TOWN OF ADDISON
 BUILDER'S COPY OF PLANS
 This set of plans contains various corrections and comments
 made by the City Staff. All trades will be required to comply
 with these corrections and comments. Failure to inform
 all trades of this information will not be accepted as a reason
 to approve construction which is in violation of local
 ordinances.
 This set of plans is to be kept on the job site at all times
 and is to be made available for use by city inspectors at
 their request. Failure to have these plans available may
 delay approval of a requested inspection.

01 FIRST FLOOR PLAN - PLUMBING
 P2.1

**ADDITION TO
 PUBLIC WORKS SERVICE CENTER**
 Westgrove Road
 Addison Texas

SHEET NO.
P2.1
 OF SHEETS
 JOB NO: 851-137

01 FIRST FLOOR PLAN - PLUMBING  
 P2.1

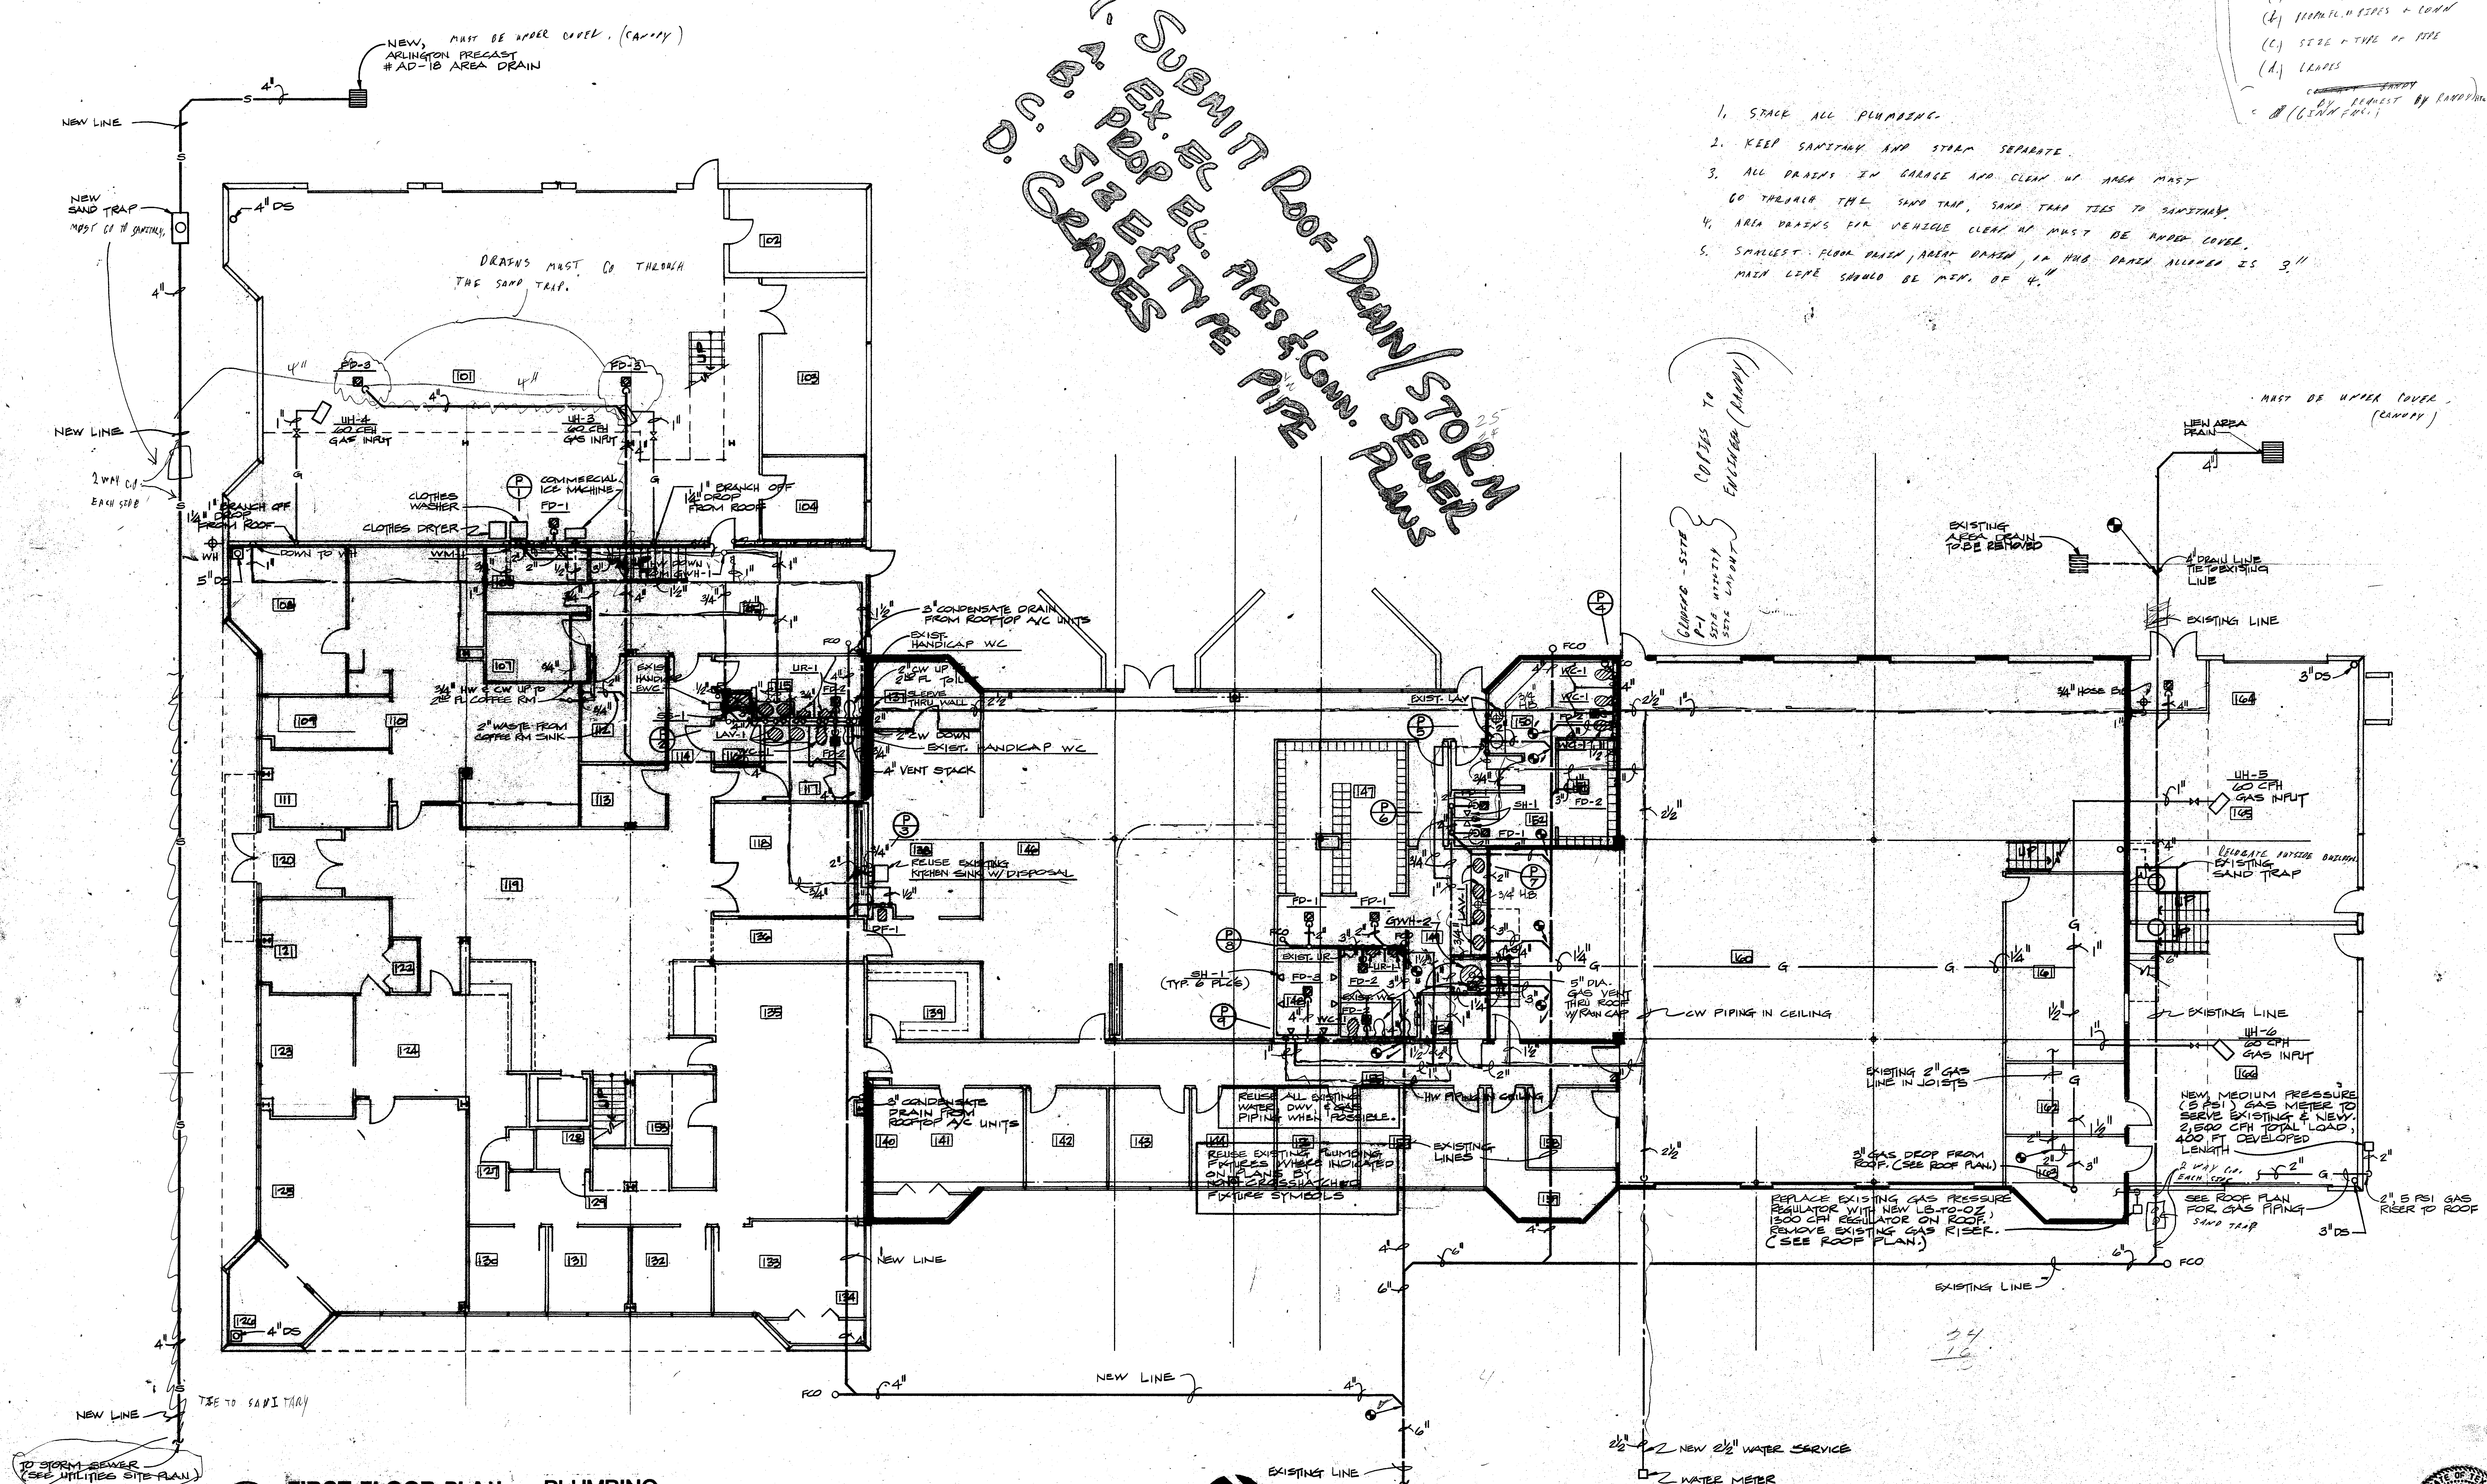
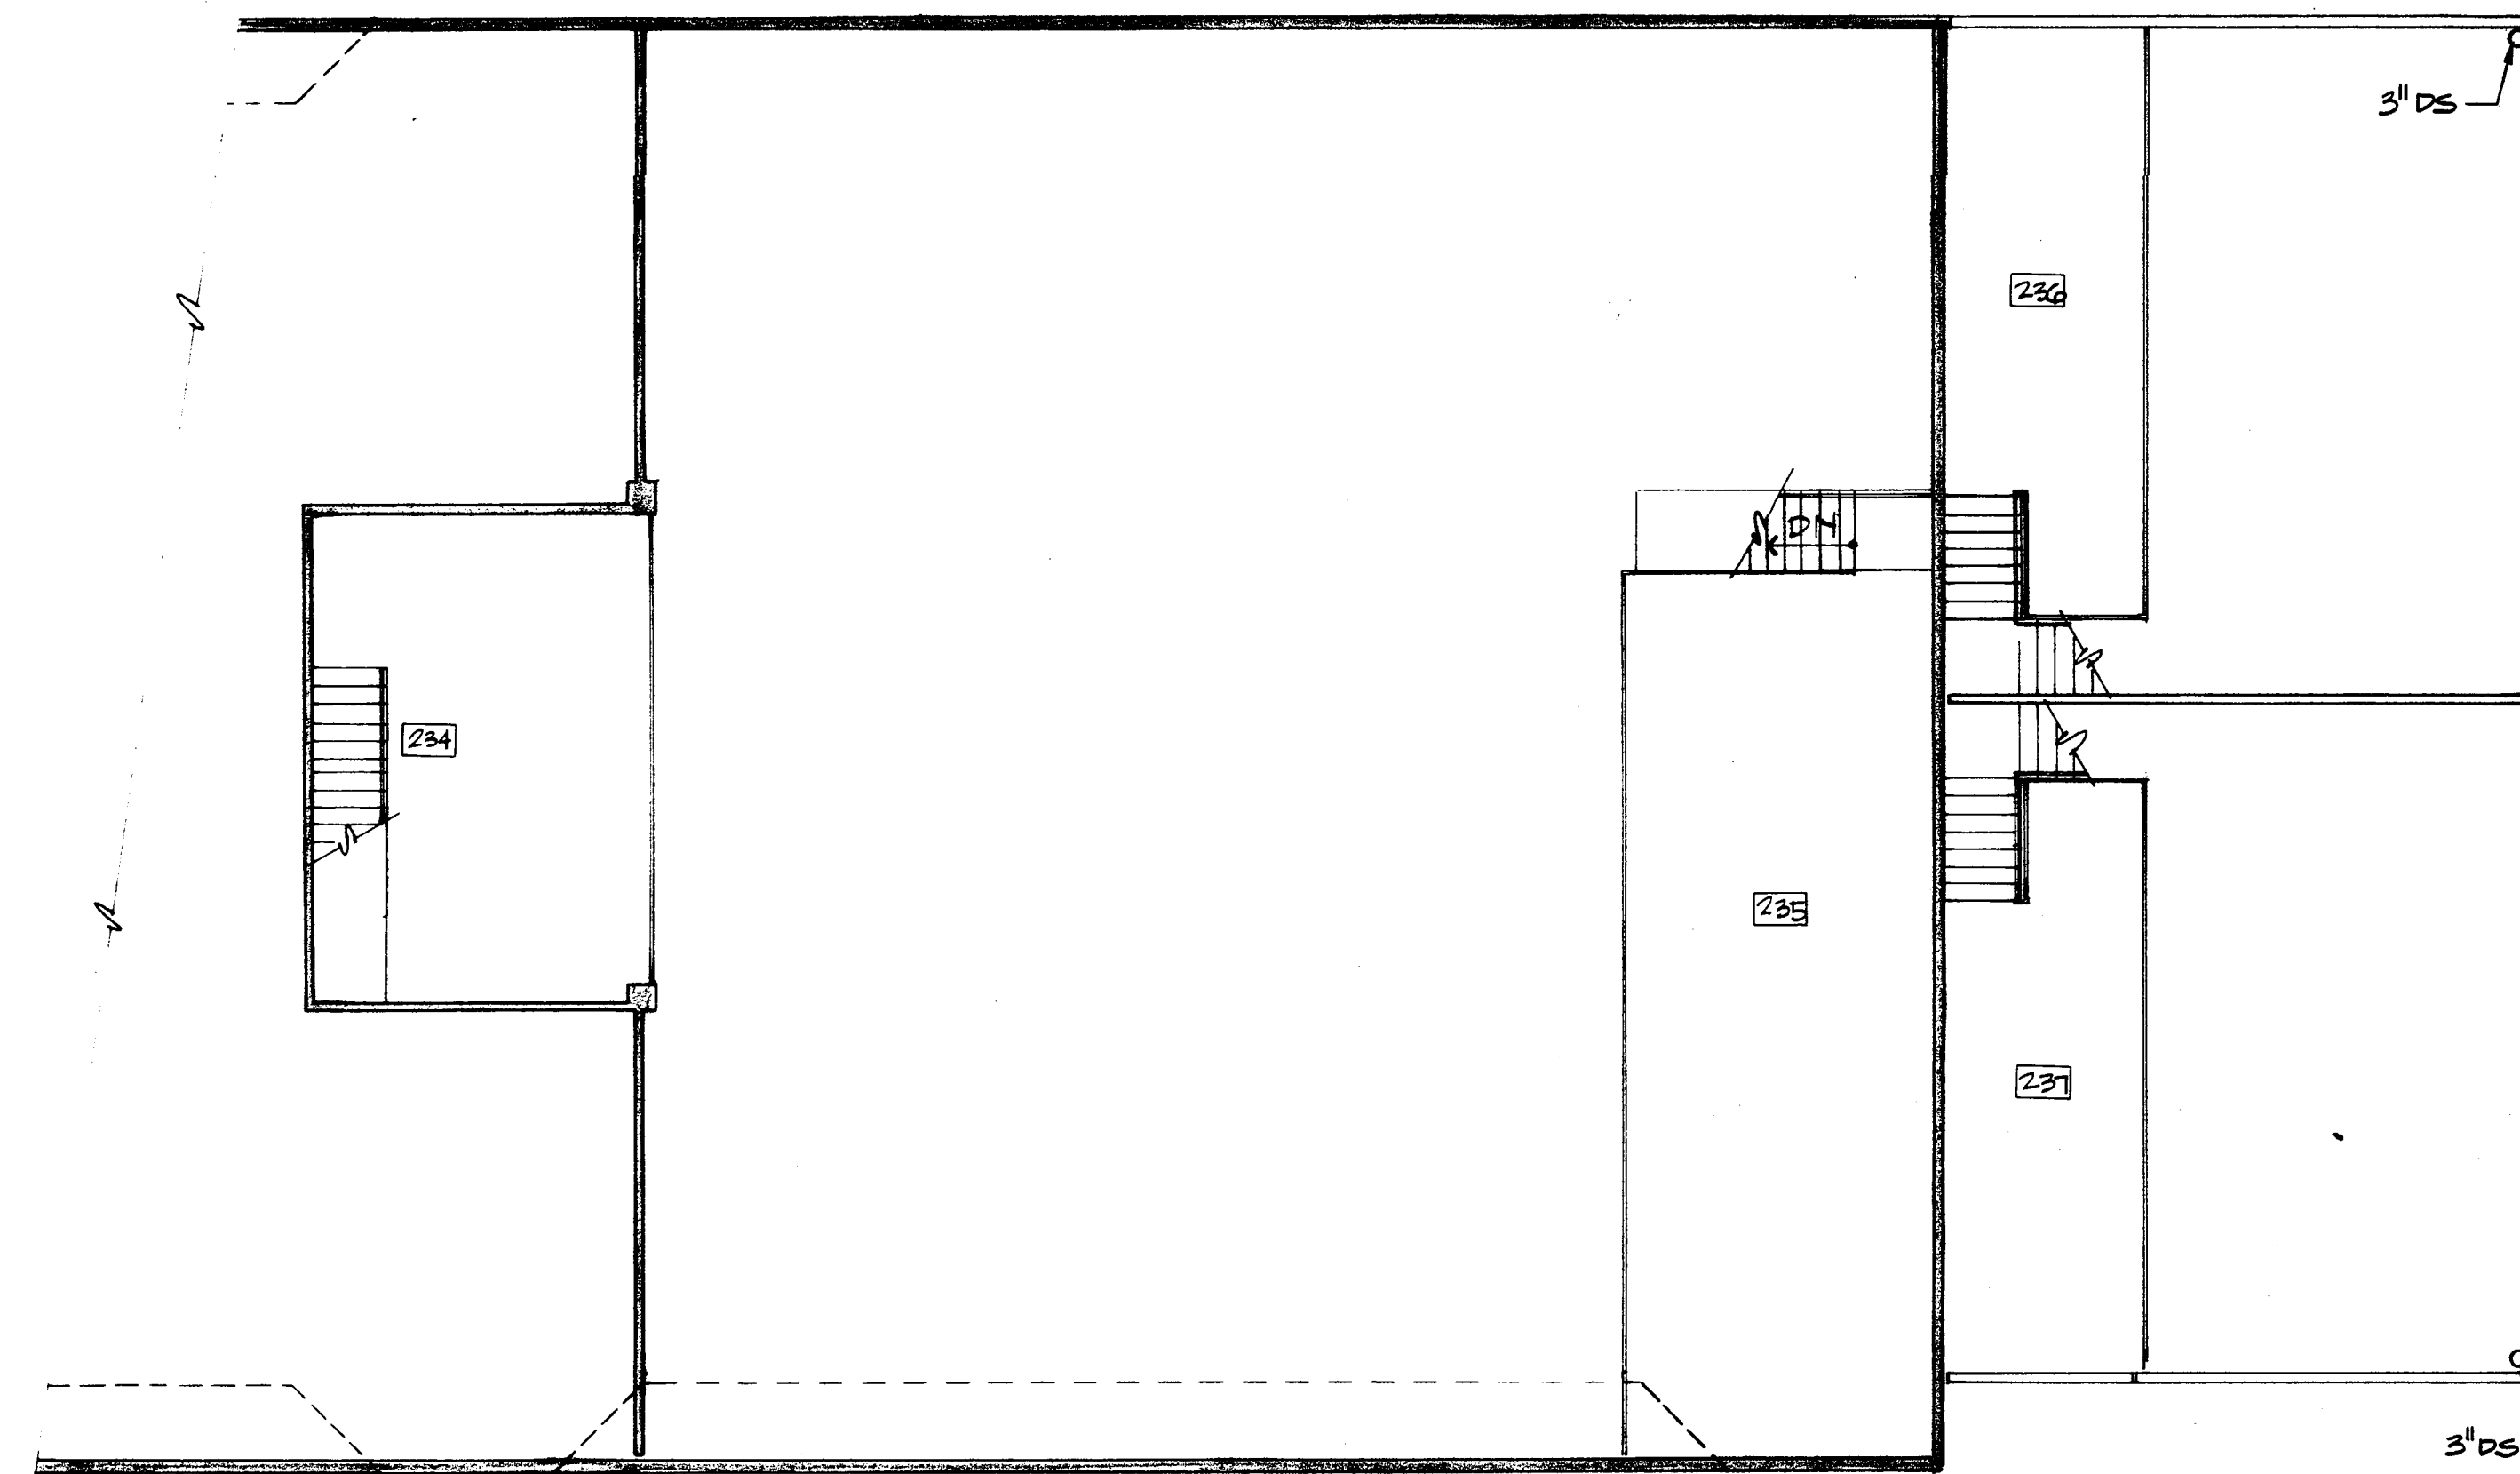
PLUMBING ISSUED IN FULL SCALE CONTRACTS
 NO UTILITIES TO BE
 INSTALLED UNTIL THE
 FOLLOWING PLANS ARE SUBMITTED
 AND APPROVED BY ENGINEER
 AND UTILITY COMPANIES.

1. COMPLETE SITE PLANS
2. P-1 (REVISED PLUMBING PLANS)
3. SITE UTILITY PLANS
4. SITE LAYOUT PLANS

1. SUBMIT ROOF DRAIN/STORM SEWER PLANS
2. EX. EL. PIPES & COMM. SEWER PLANS
3. SIZE & TYPE PIPE GRADES

1. STACK ALL PLUMBING.
2. KEEP SANITARY AND STORM SEPARATE.
3. ALL DRAINS IN GARAGE AND CLEAN UP AREA MUST GO THROUGH THE SAND TRAP, SAND TRAP TIES TO SANITARY.
4. AREA DRAINS FOR VEHICLE CLEAN UP MUST BE UNDER COVER.
5. SMALLEST FLOOR DRAIN, AREA DRAIN, IN HUB DRAIN ALTHOUGH IS 3" MAIN LINE SHOULD BE MIN. OF 4".
